From: Martyn White
Sent: 13 August 2019 13:40
To: Planning.Responses <Planning.Responses@arun.gov.uk>
Cc: Zac Denton <Zac.Denton@arun.gov.uk>
Subject: AB/71/19/L

AB/71/19/L

Number 52 Tarrant Street is a Grade II mid-19th Century Listed terraced town house. The house is on 3 storeys with a semi-basement, and there are double hung sash windows and a panelled door with moulding and semi-circular fanlight over. Five ashlar steps rise to the front door with iron railings which have spear finials. It is of red brick with grey headers in two recessed panels. There is a pitched slate roof and red brick chimneys present.

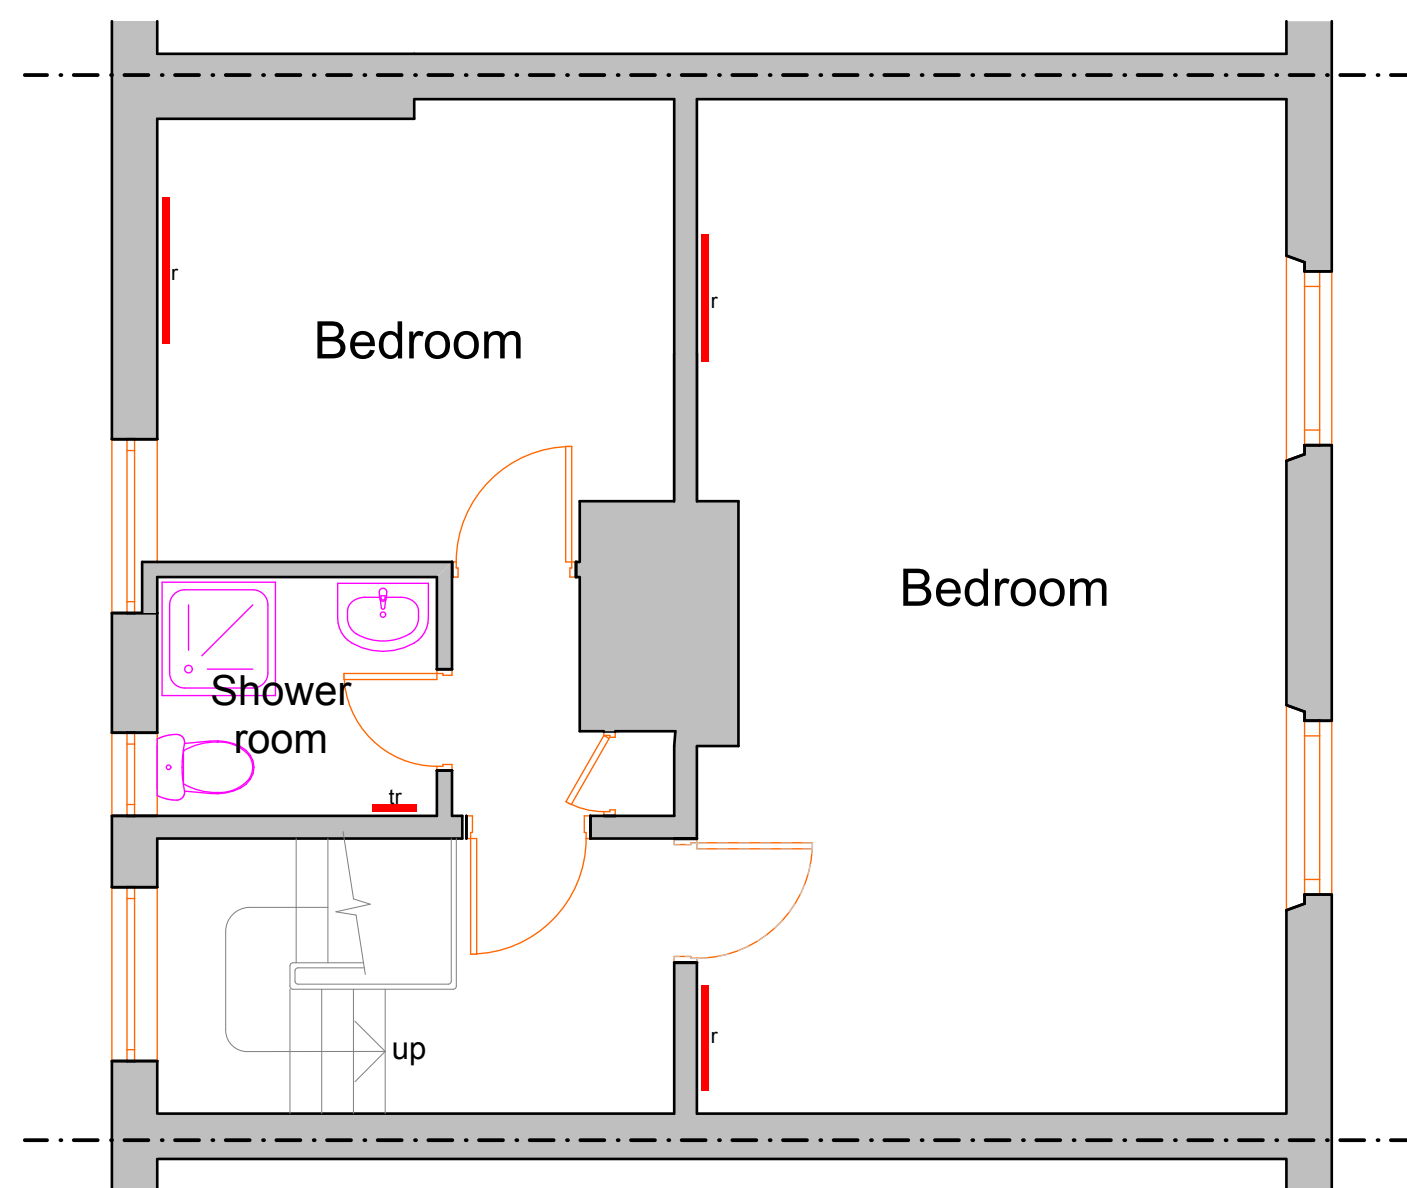
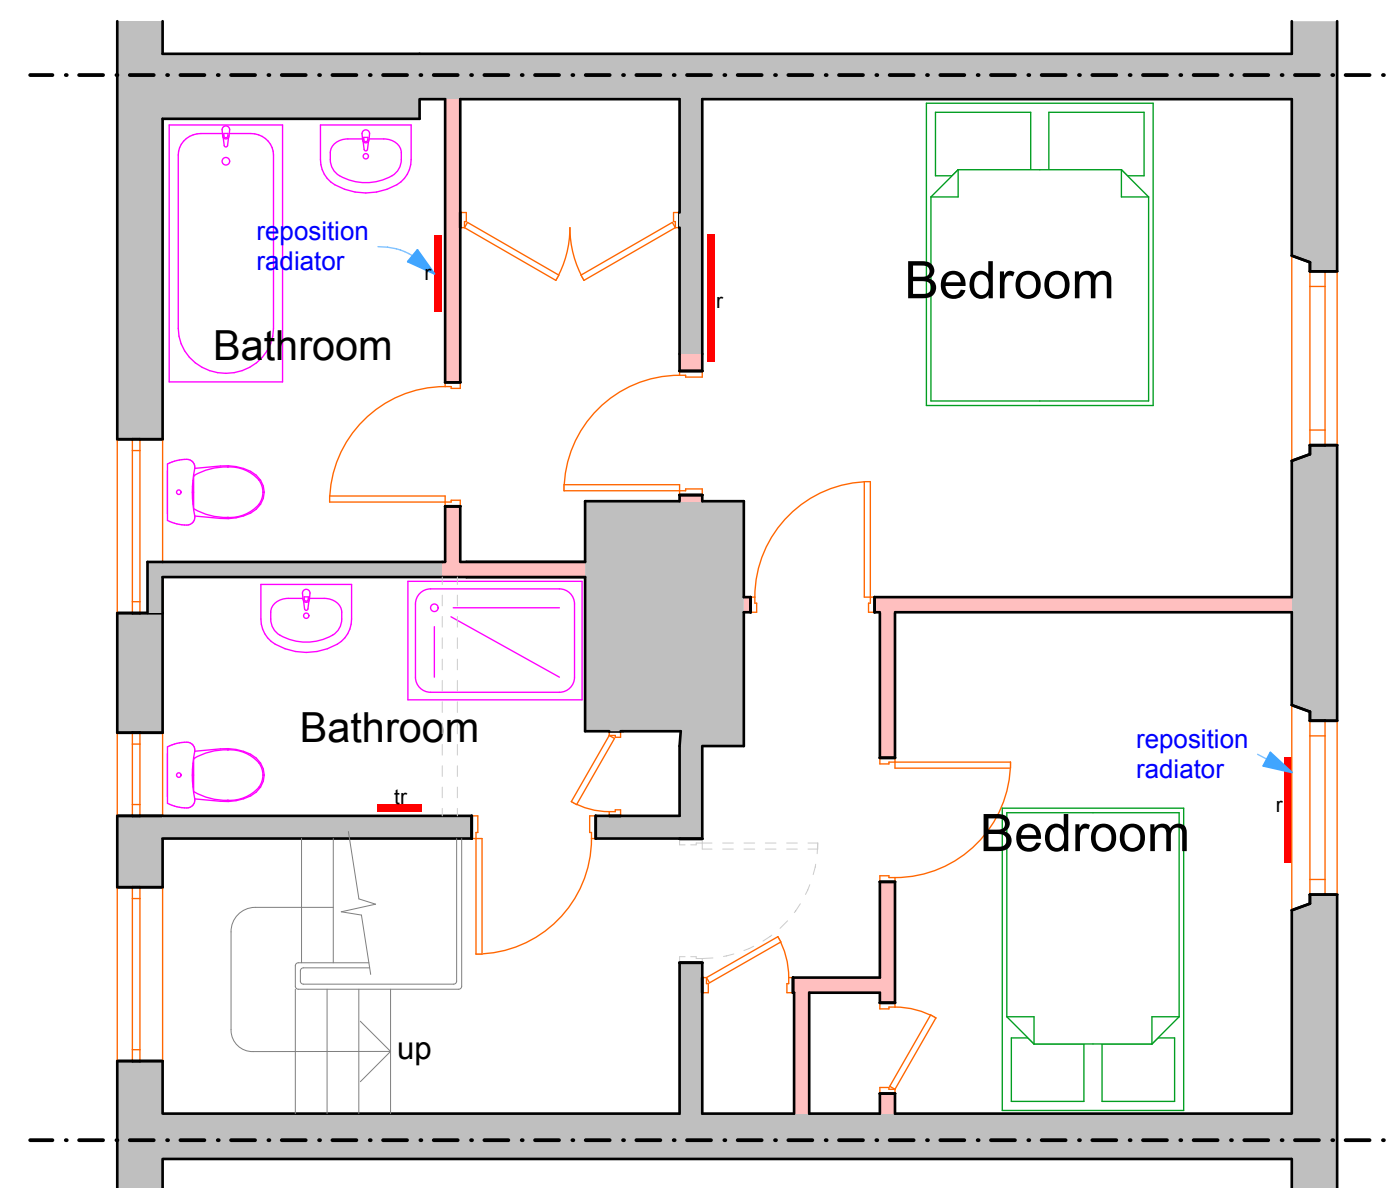
I note that the works to the existing shower room involve the removal of modern studwork and closing a modern door opening. Such works will not harm the listed building.

The insertion of modern studwork to create an additional bedroom and bathroom/dressing area will alter the floor plan. It is noted that the justification is to utilise what is considered to be 'wasted' space. On balance, it is considered that these alterations would allow the floor plan to be more efficiently used and can easily be removed at some point in the future.

It is not clear if the existing bedroom door is to be re-used as part of the proposal. Please can this be confirmed?

The works will involve additional connections to the existing drainage and soil/vent pipes to the rear of the building. Such works seem to be minimal, subject to ensuring that limited existing historic fabric will be removed/affected.
